NC DEPARTMENT OF  
**HEALTH AND  
HUMAN SERVICES**

August 3, 2022

Re: Project No. HL-11358-MAS/TKM  
FID No. 120572  
Good Hope Hospital  
Psychiatric Bed Expansion  
Erwin (Harnett County)

The referenced project was inspected on July 27, 2022 by Mark Saulnier, Tony McQuage, Jerry Boyle and Luis Padilla. This project cannot be approved until the following deficiencies have been corrected:

1 LIFE SAFETY PLAN
SCALE: 1/8"=1'-0"

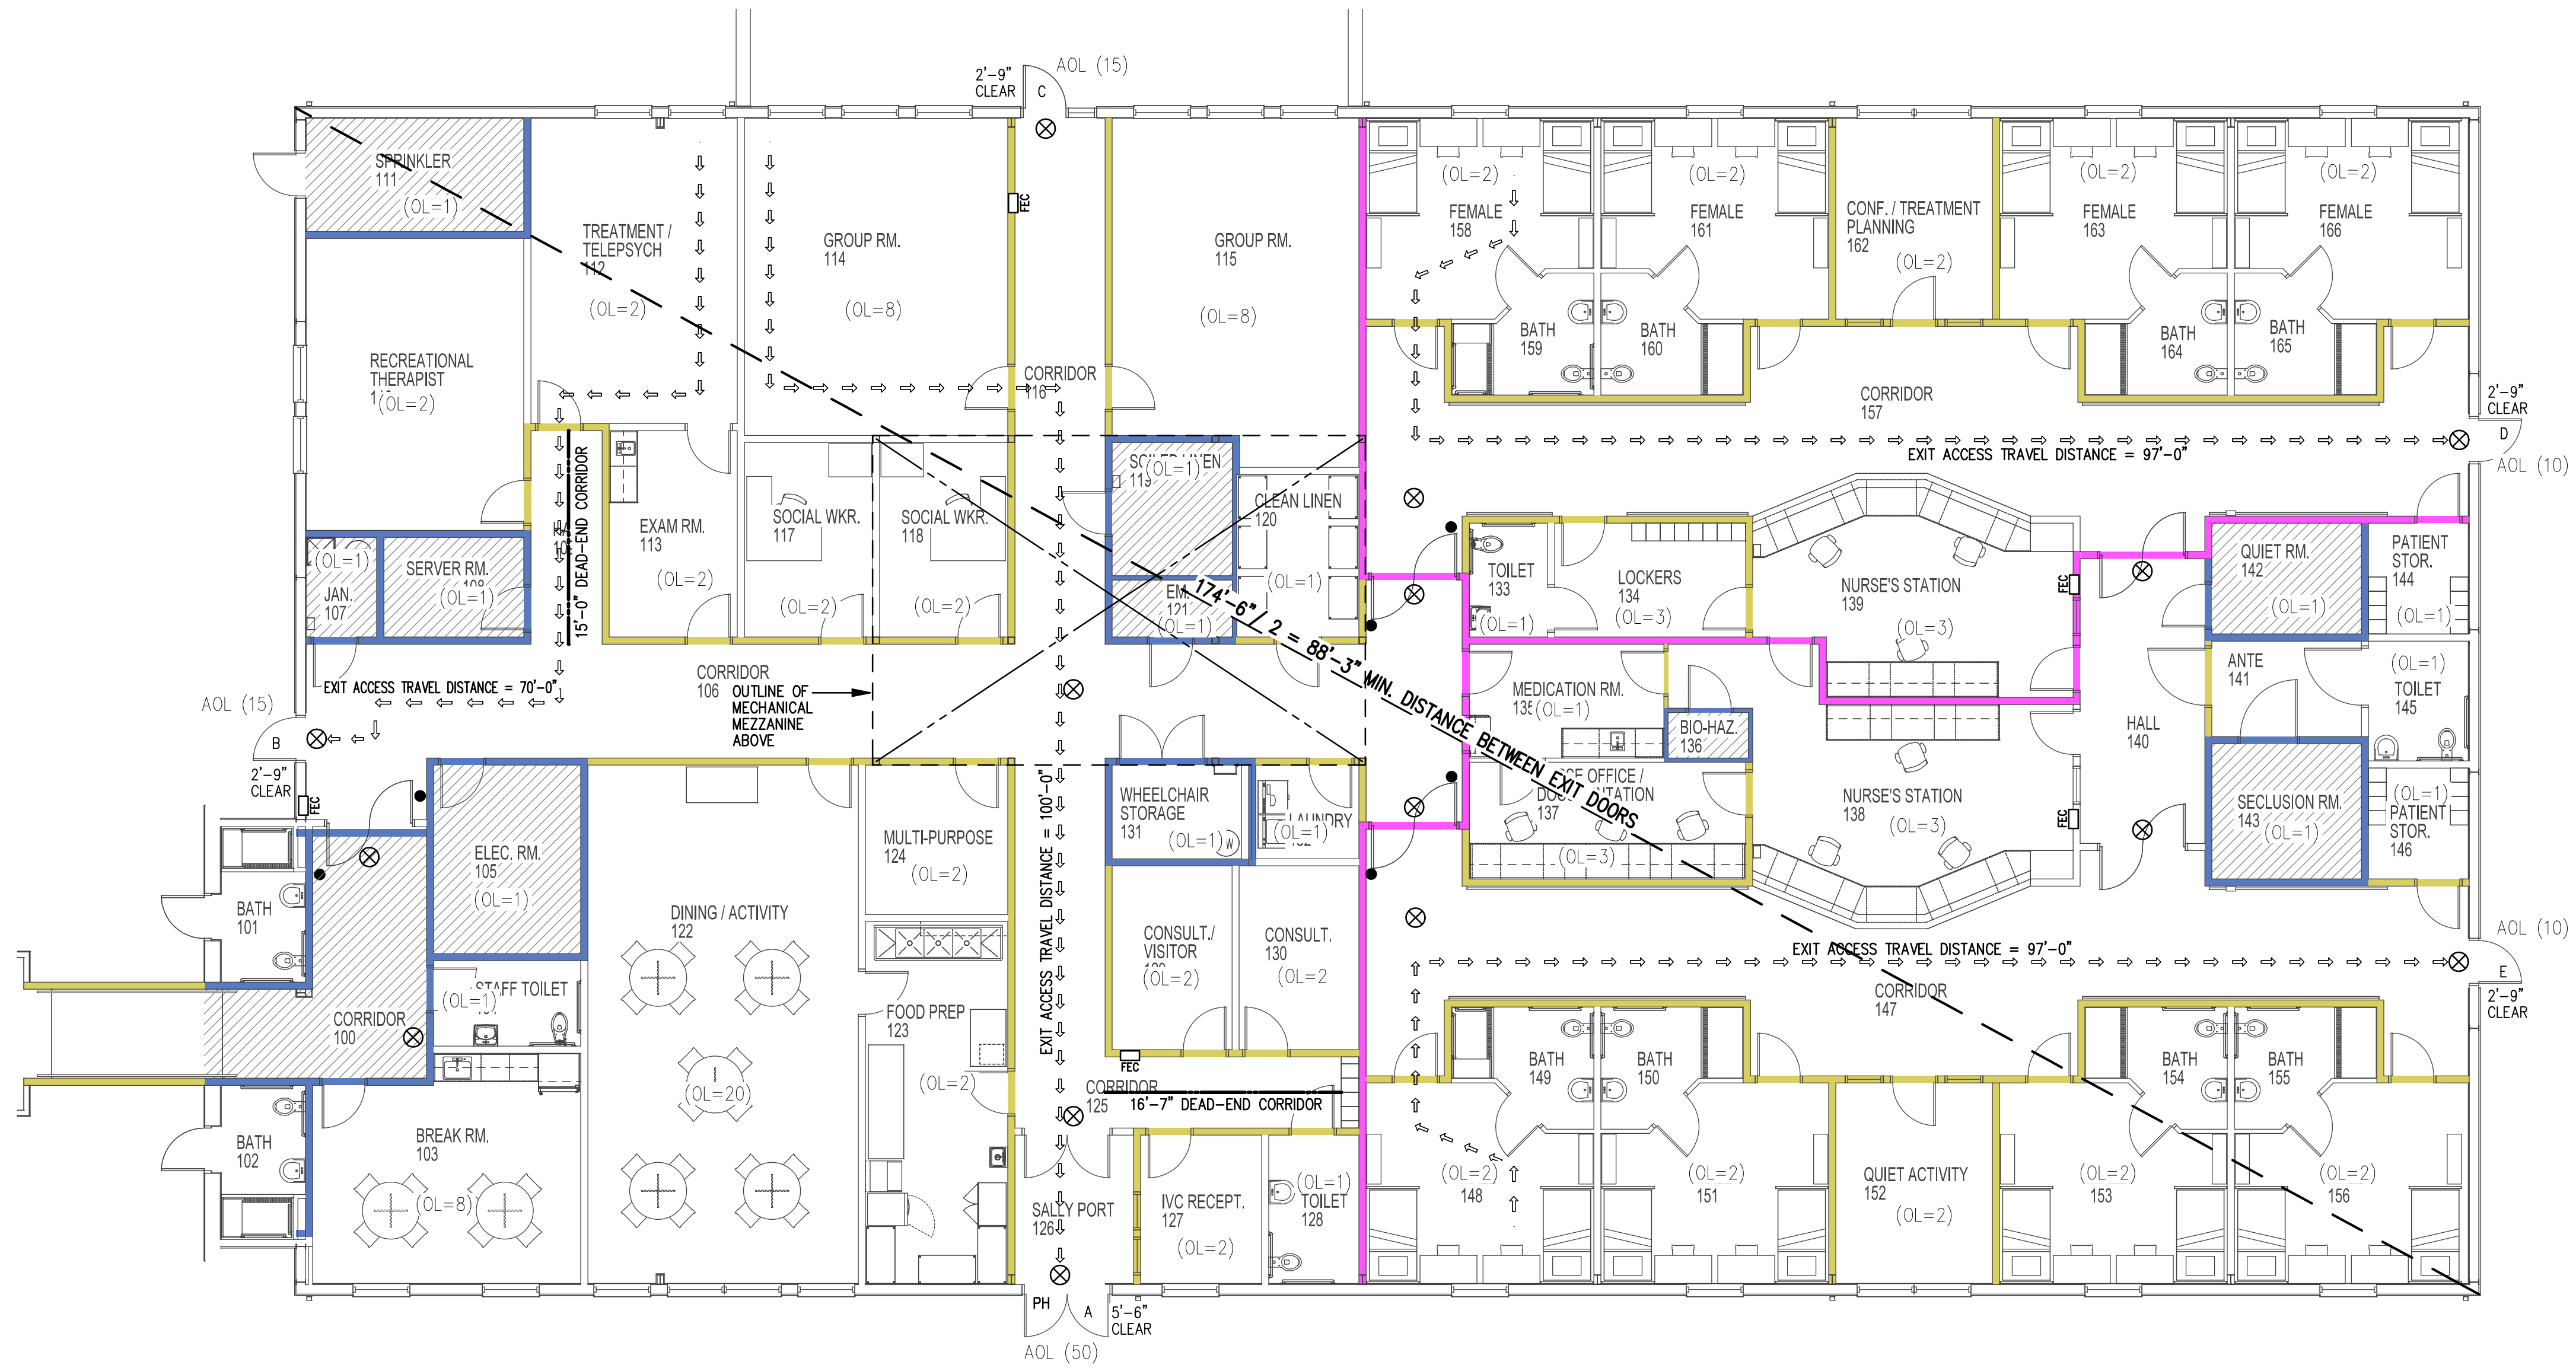
1. At Nurse Station 139, the glass in the smoke barrier was not rated. It must be a minimum 45-minute fire-protection-rated glazing per NCSBC Table 716.6

2. At Nurse Station 139, the fire extinguisher cabinet must be 5 sided behind the cabinet to maintain the 1-hour smoke barrier. Also cover the junction box above the ceiling.

3. There was a discussion about the connection to the existing building. Our understanding is that there is a 1-hour smoke barrier around Corridor 100 and a smoke barrier lid over corridor 100 to separate the new from existing into separate smoke compartments. Confirm that the lid is a 1-hour assembly and that all of the walls surrounding Corridor 100 are labeled as 1-hour smoke barriers and that the cross-corridor Doors 100 have an astragal at the meeting edge.

4. In Bath 133, the paper towel/trash dispenser must be 5 sided behind the dispenser to maintain the 1-hour smoke barrier.
5. In all patient accessible areas where they are not under constant physical supervision, change the screws at the door hardware to tamper resistant.

1 ELECTRICAL POWER - FLOOR PLAN
1/8"=1'-0"

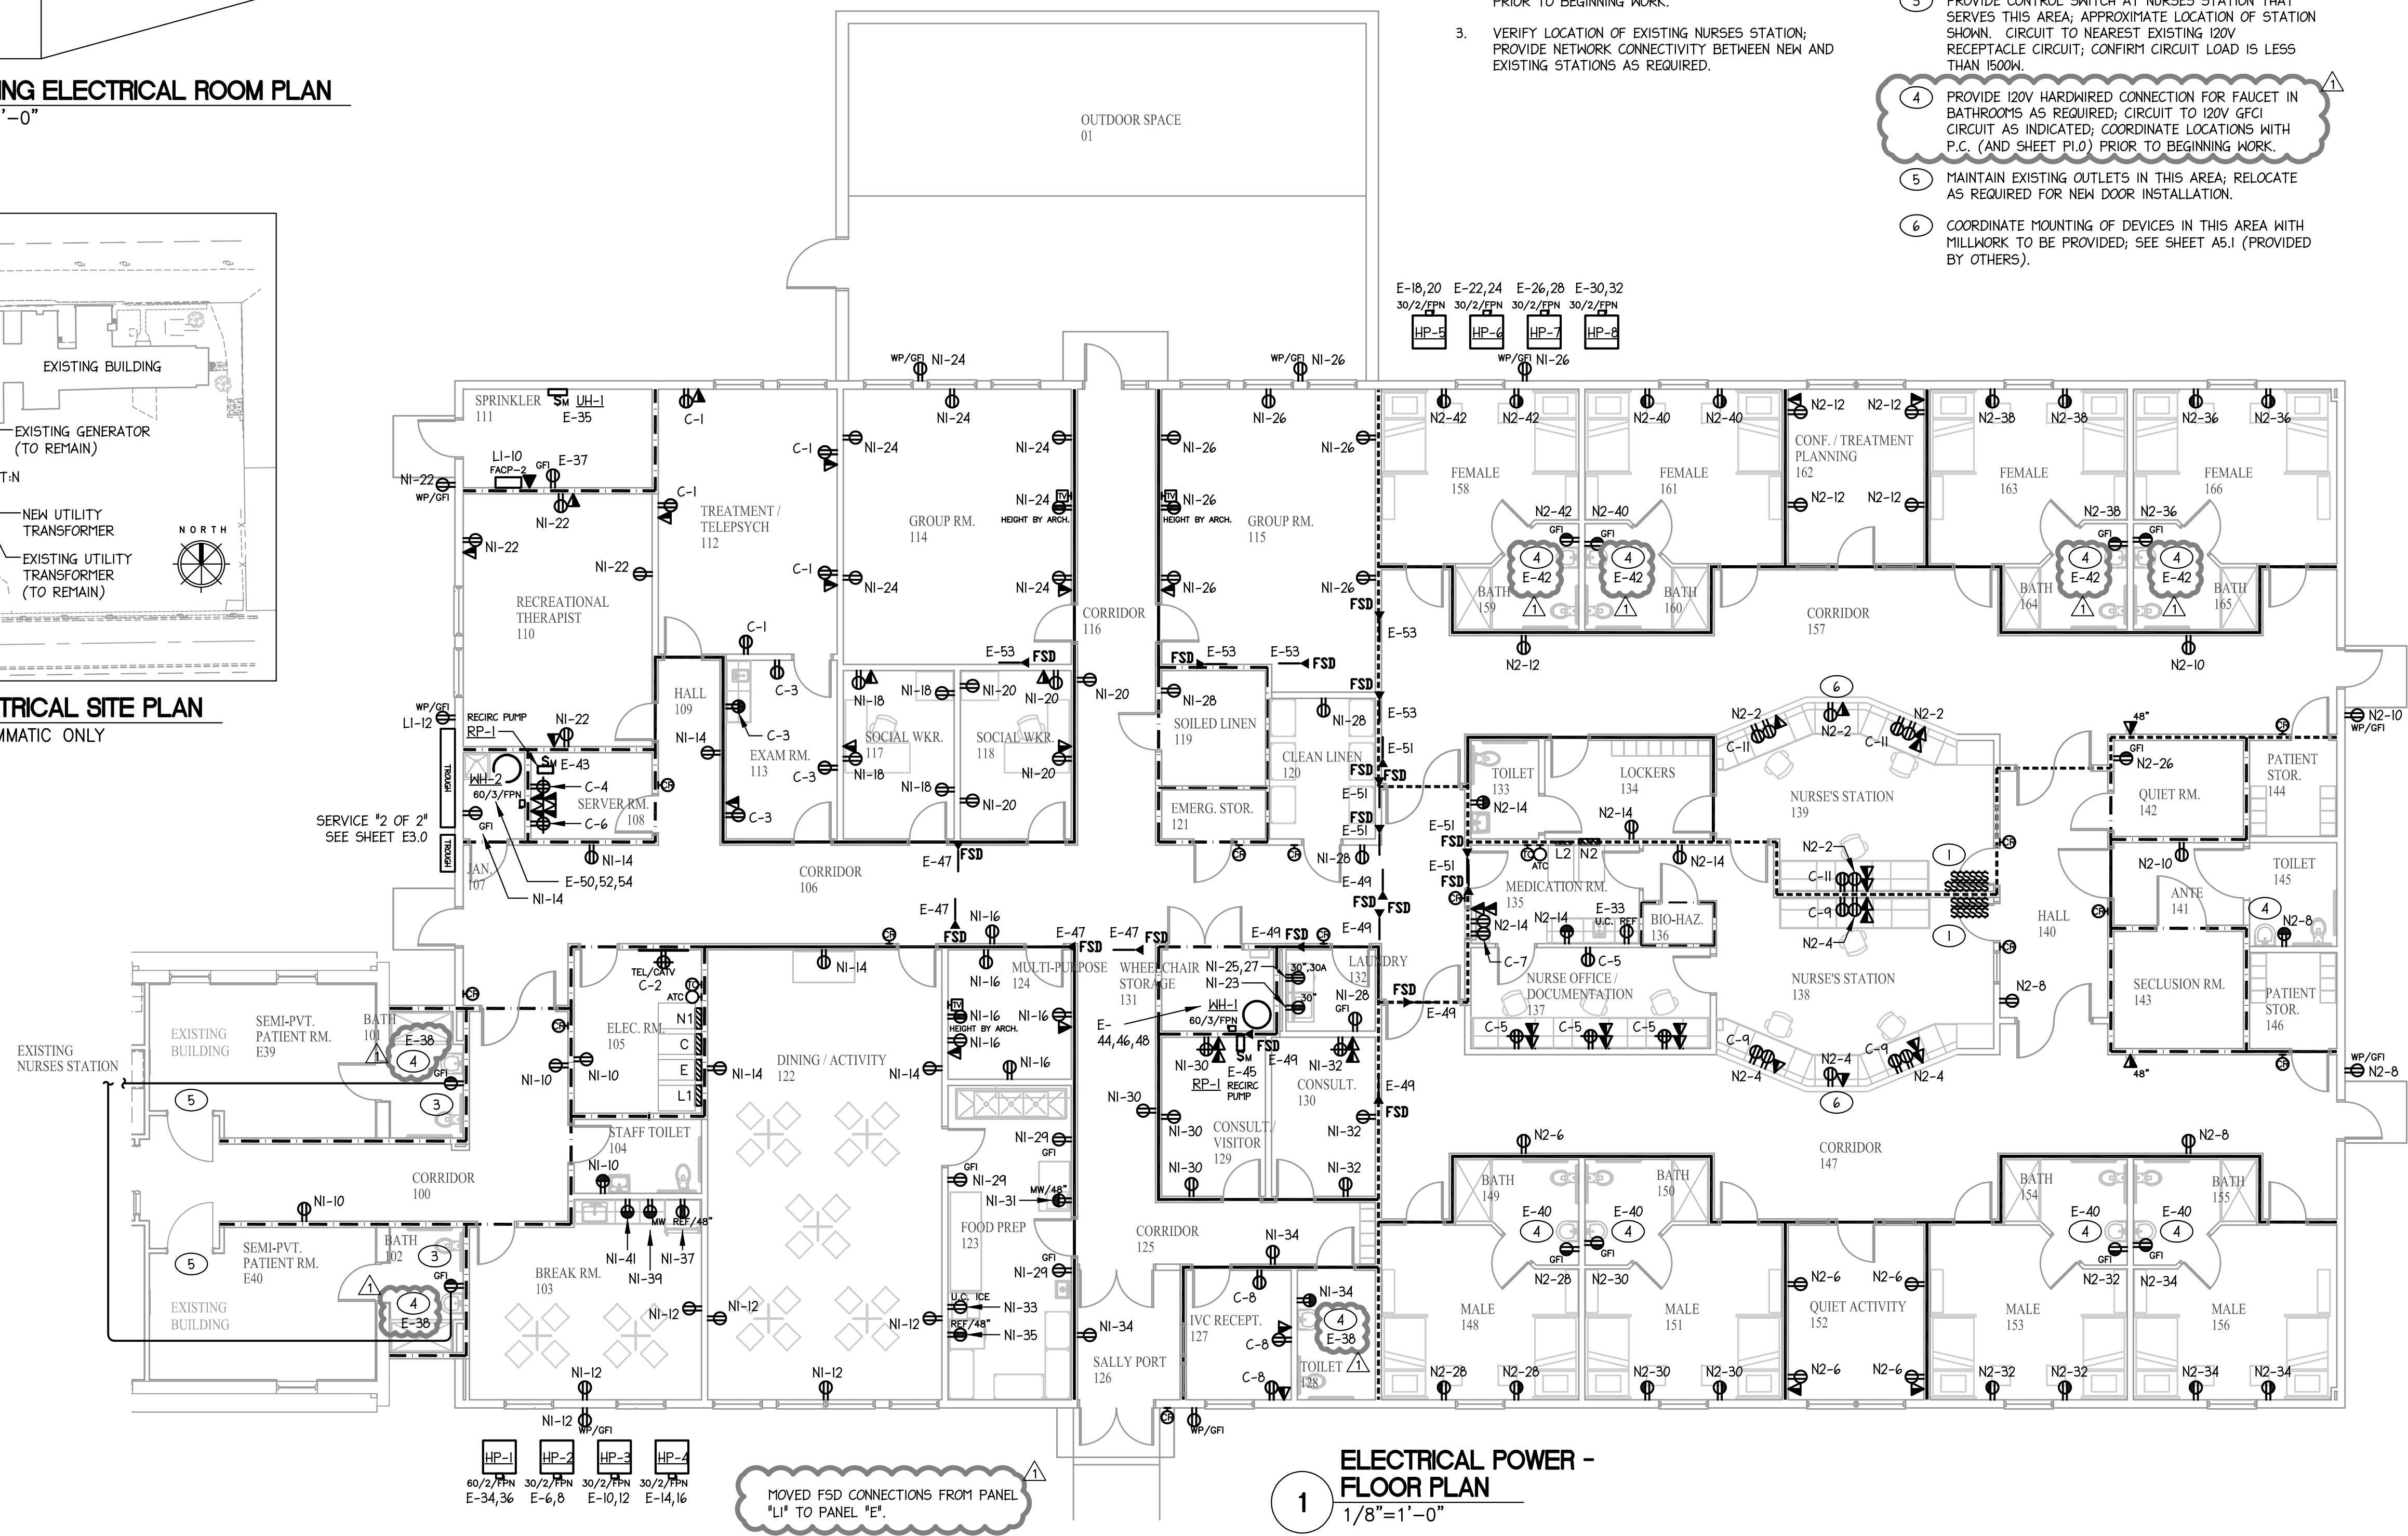
32. Provide critical branch illumination and receptacles in Nurses' stations and medication prep rooms. [2017 NEC, 517.34 (A) (3) b. g.]
33. Provide critical branch power to nurse call system. [2017 NEC, 517.34 (A) (5)] The nurse call system is currently connected to normal power.

34. Receptacles supplied by the essential electrical system shall have a distinctive color or marking readily identifying it as connected to the emergency system. The emergency receptacle in fire sprinkler backflow enclosure was not identified. [2017 NEC, 517.31 (E)]

36. Provide GFCI protection for receptacle within (6) six feet of sink in Exam Room 113. [2017 NEC, 210.8 (B) (5)]
37. Install a remote generator emergency stop either on the building, within the building in a staff location or at the location discussed during the inspection adjacent to the portable generator connection. [2010 NFPA 110, 5.6.5.6]
